KUM & GO GAS & C-STORE

MAJOR SITE DEVELOPMENT PLAN

PCD FILE NO. PPR-2225

2232 - EL PASO, COLORADO
SECURITY BLVD. AND MAIN ST.
GRADING PLAN

SHEET NUMBER:
C2.1
6 OF 35

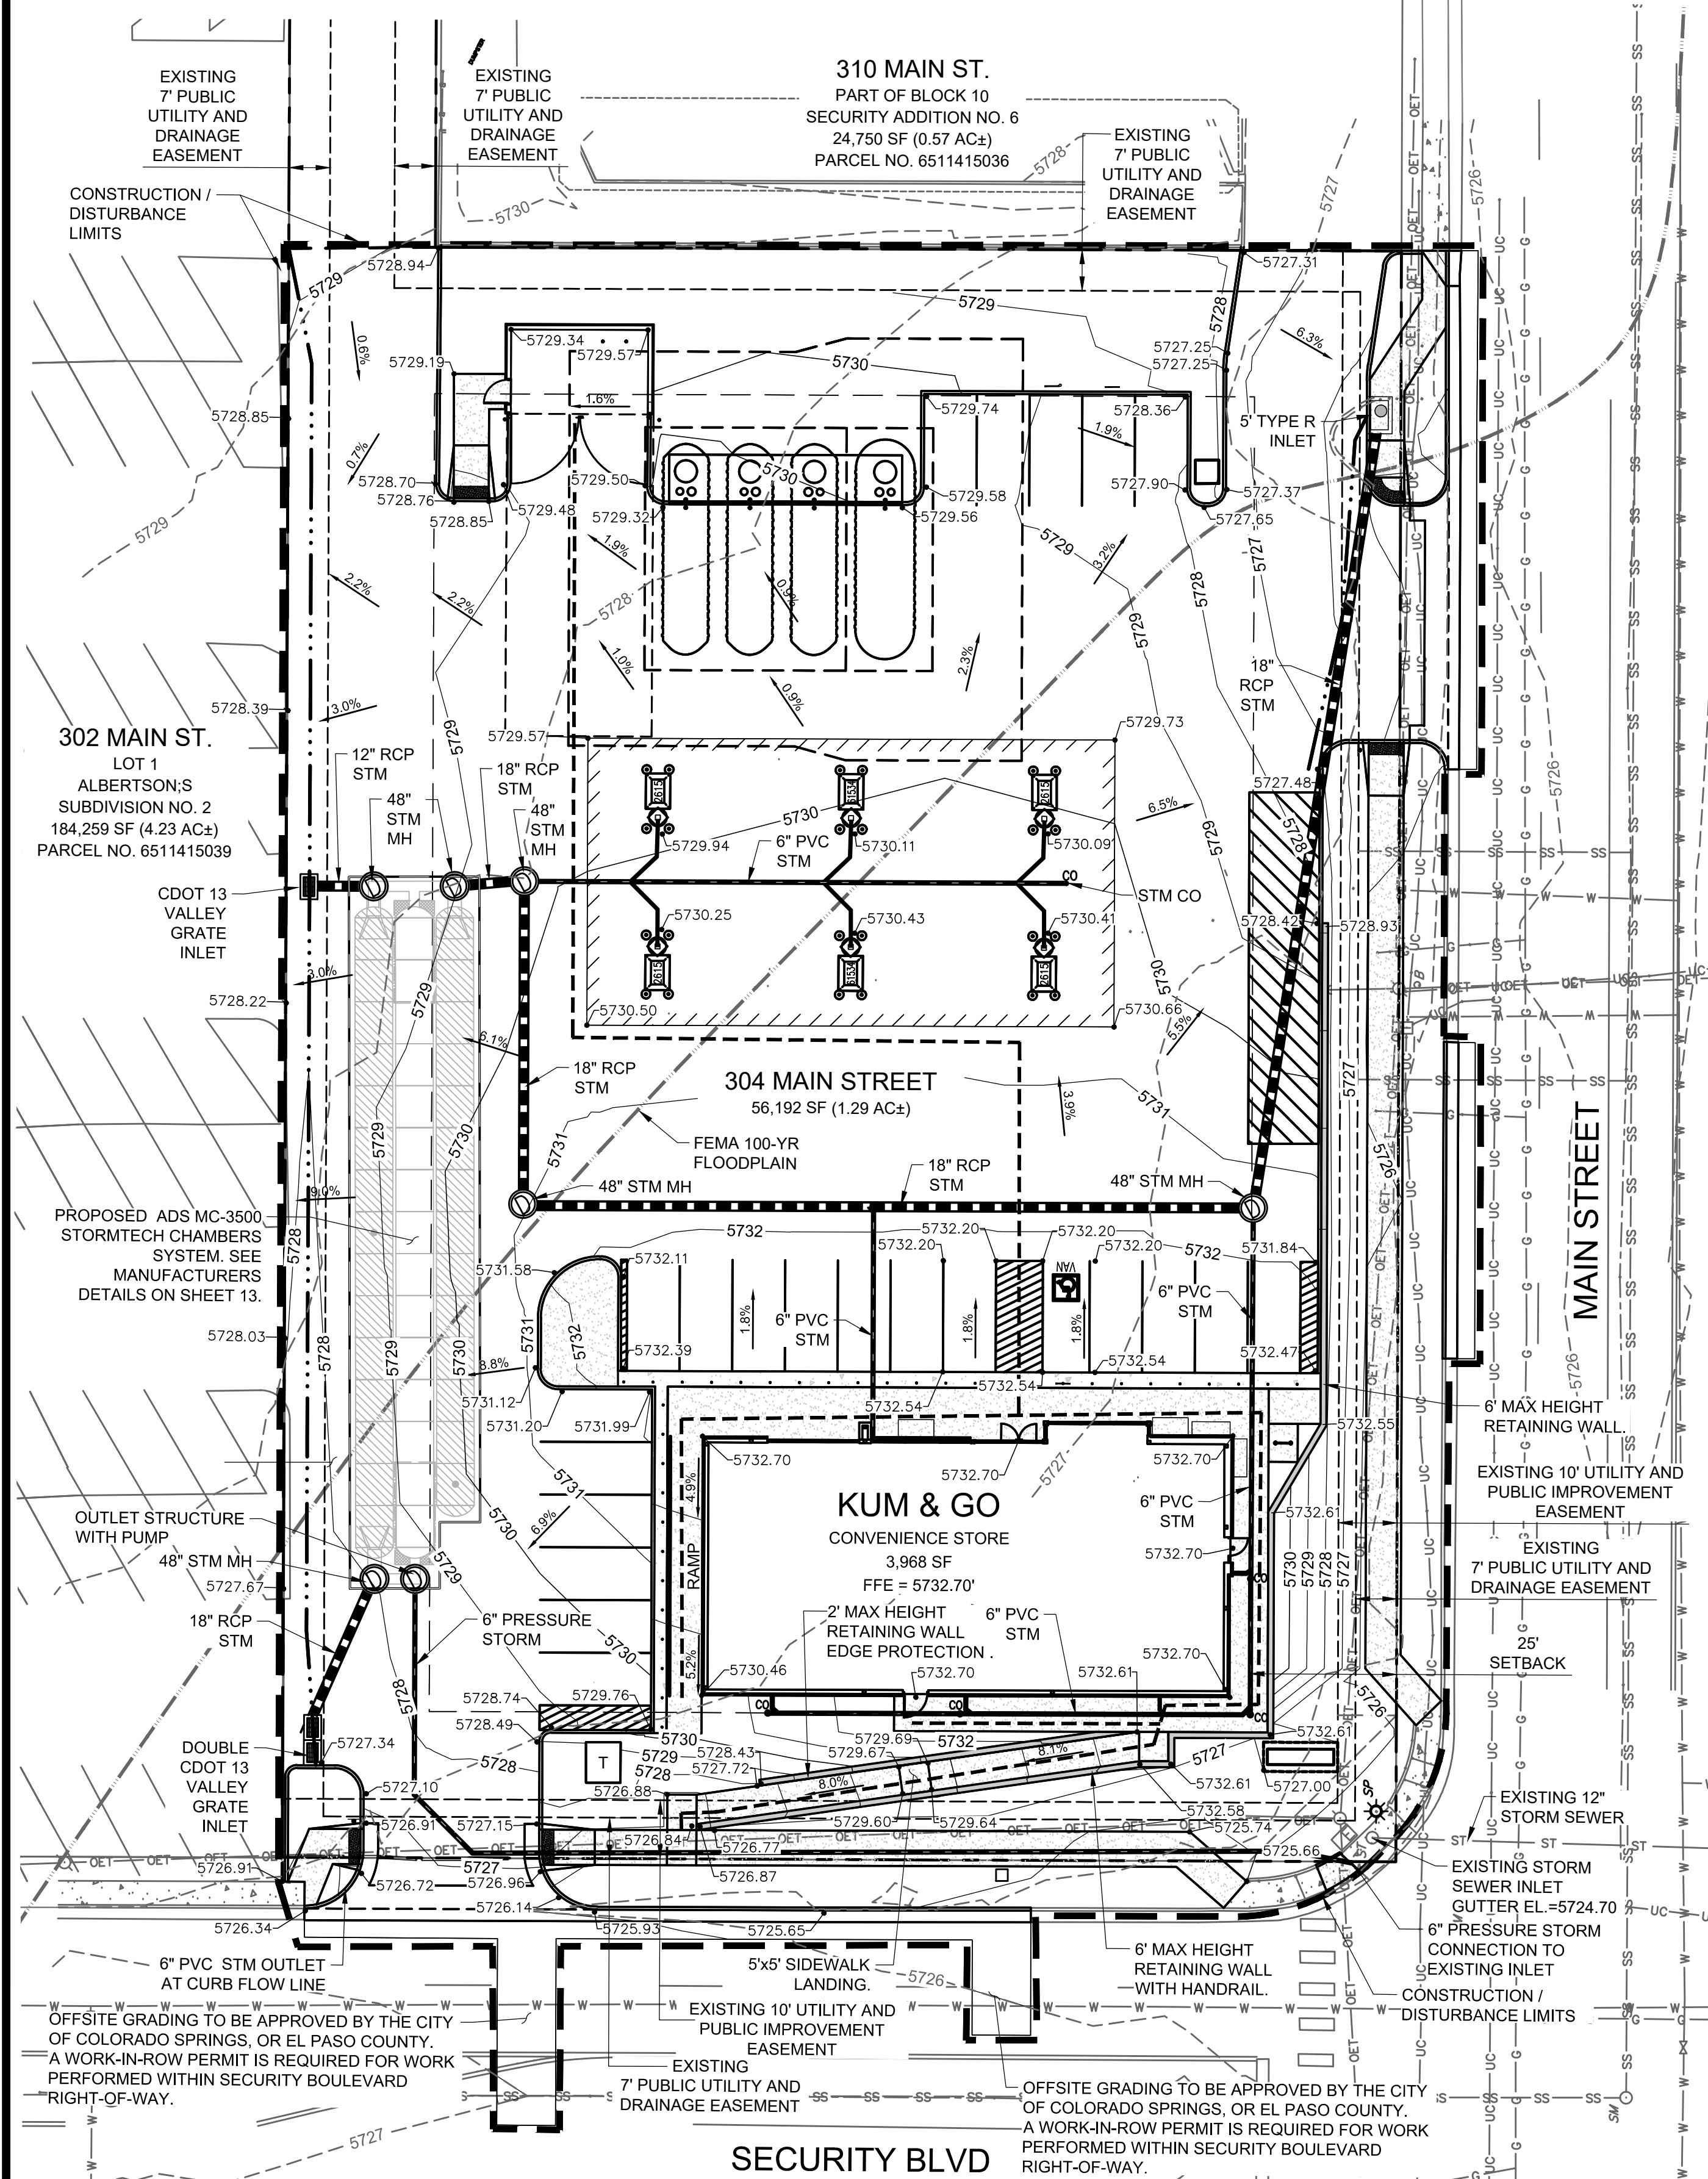
Unresolved. Update to include EPC grading and construction notes.

Added Notes. Rearranged notes/legend to fit on this sheet

DATE: 10-03-2022
 SHEET NUMBER: C3.2
 10 OF 35

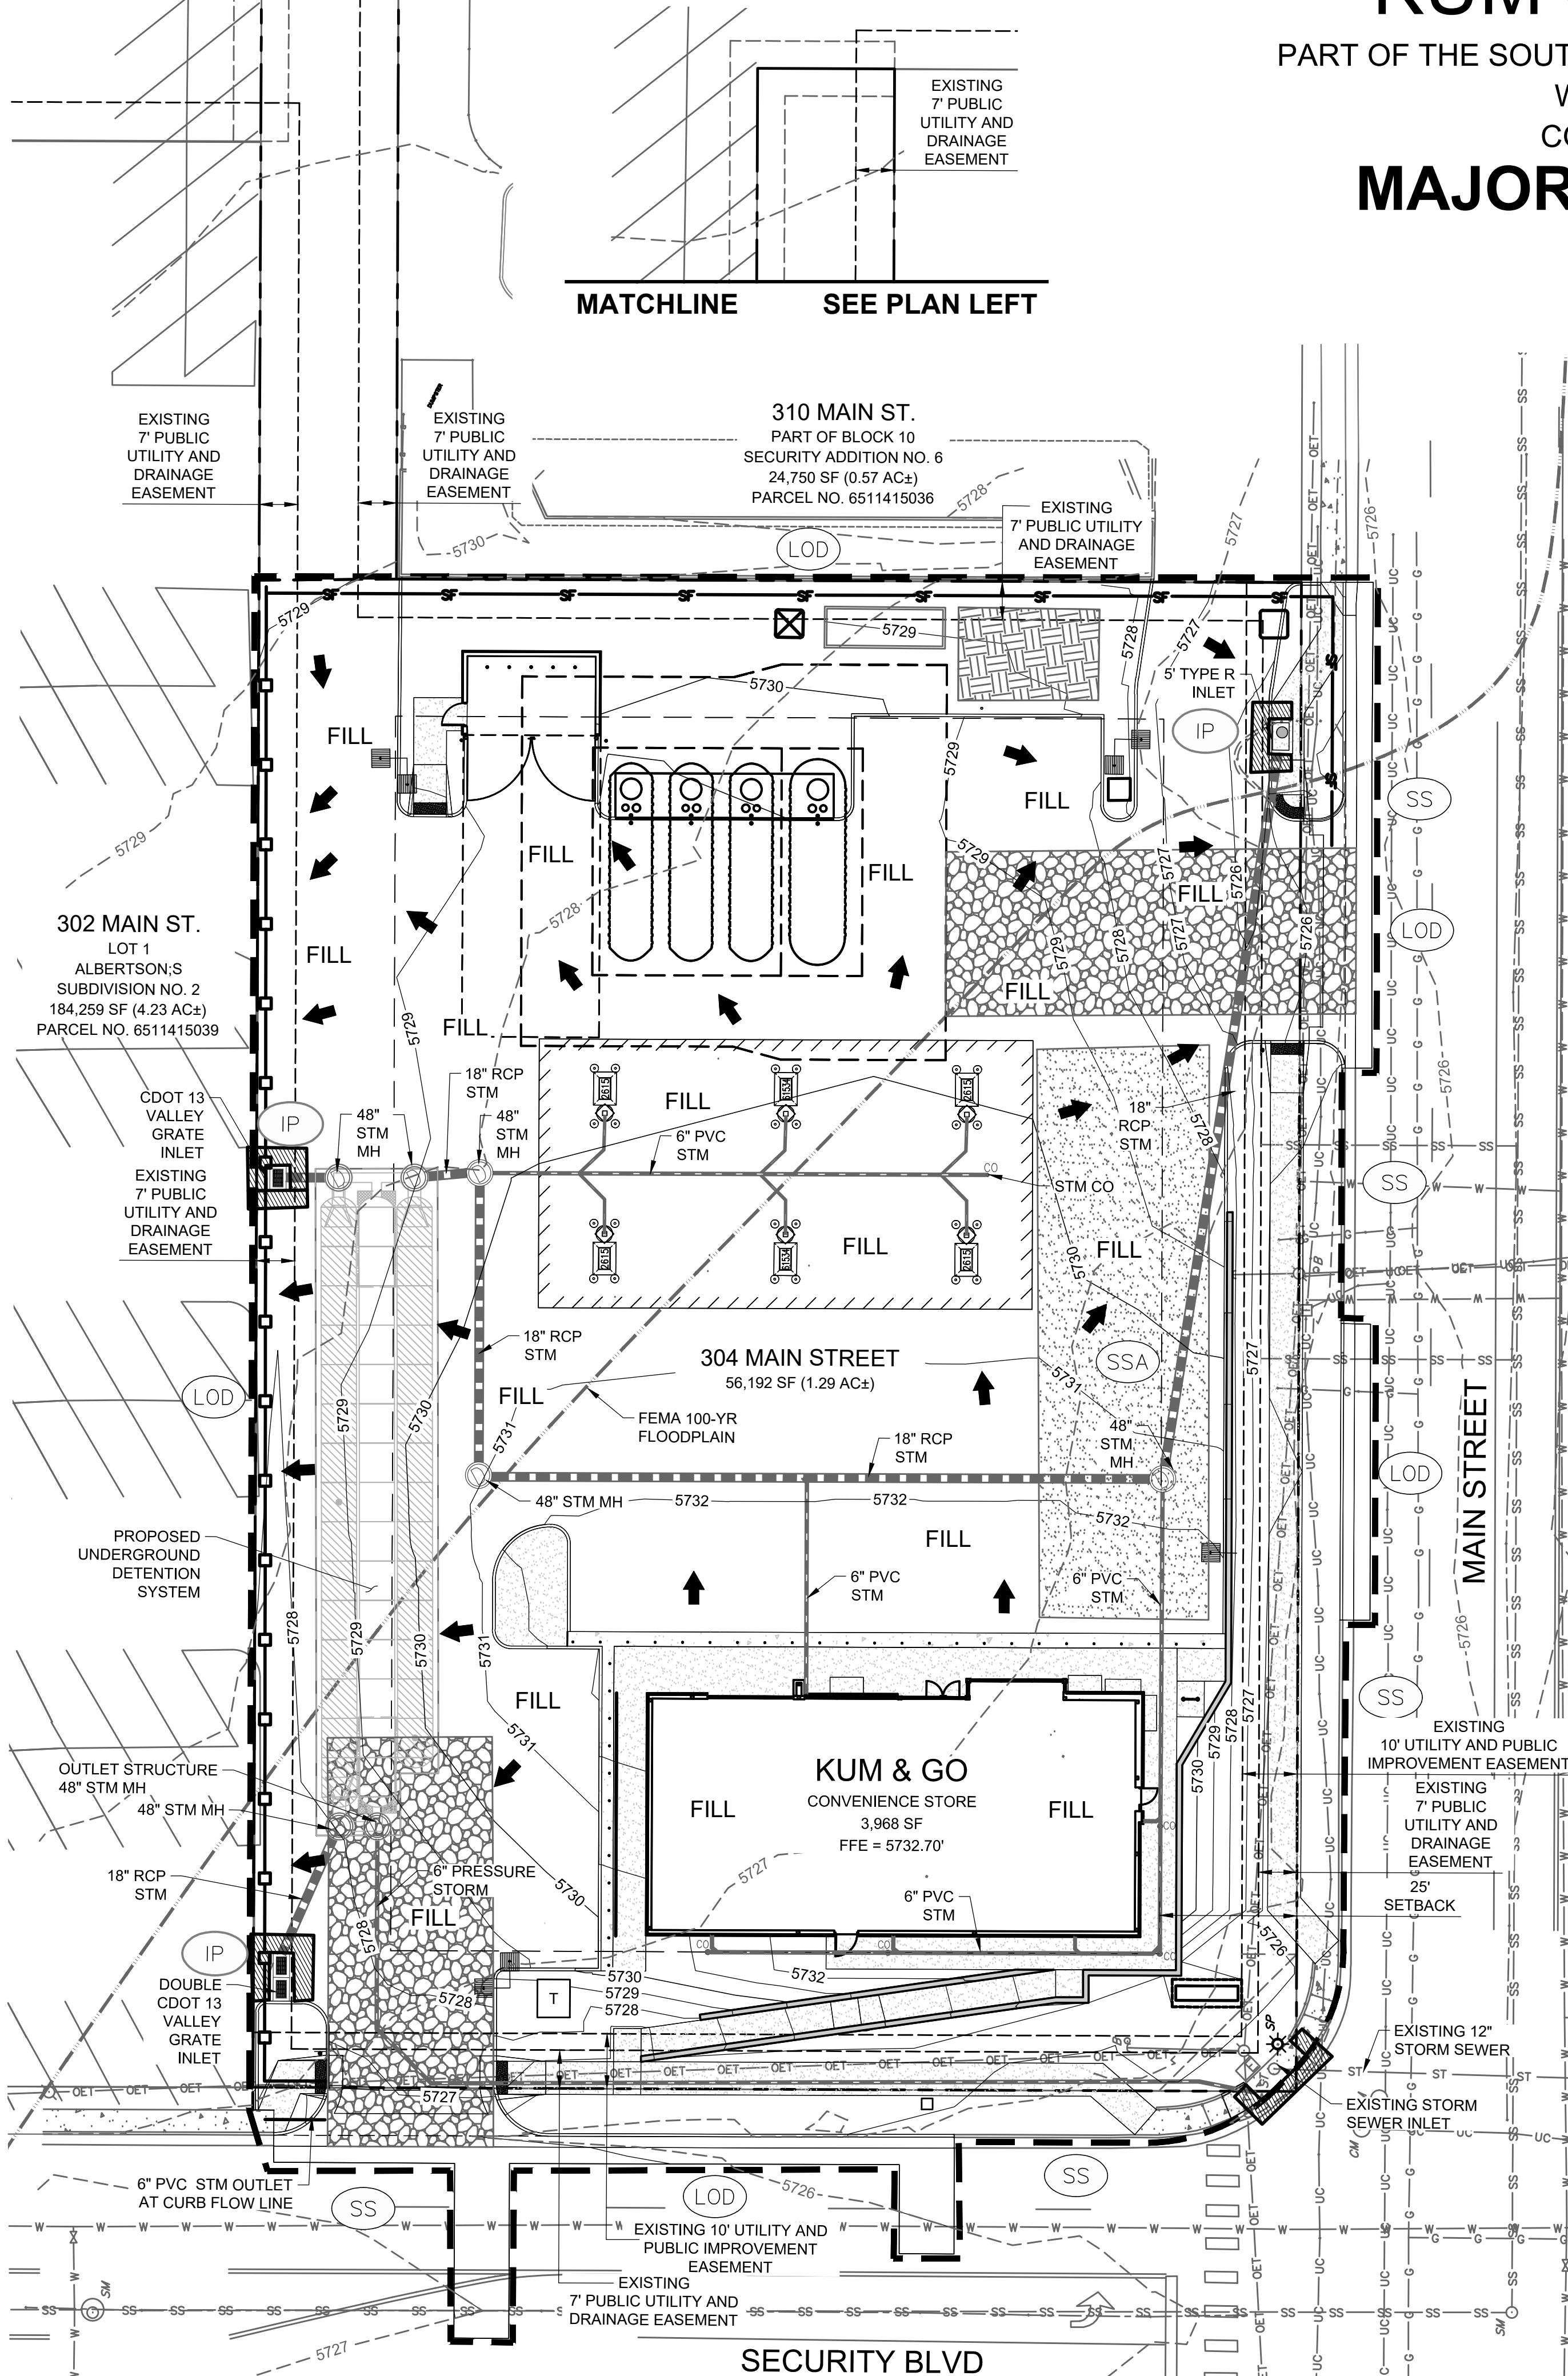
Is there a cross pan across the driveway (west-east)? Better to route the pipe to the other side of the driveway and turn pipe so it's not perpendicular to the road. As a preferred alternative - pipe outlet to existing inlet and then a pump wouldn't even be needed. Outlet pipe would need a check valve

Per meetings with El Paso County, the outlet location has been moved and is now making a connection with the existing inlet to the east.
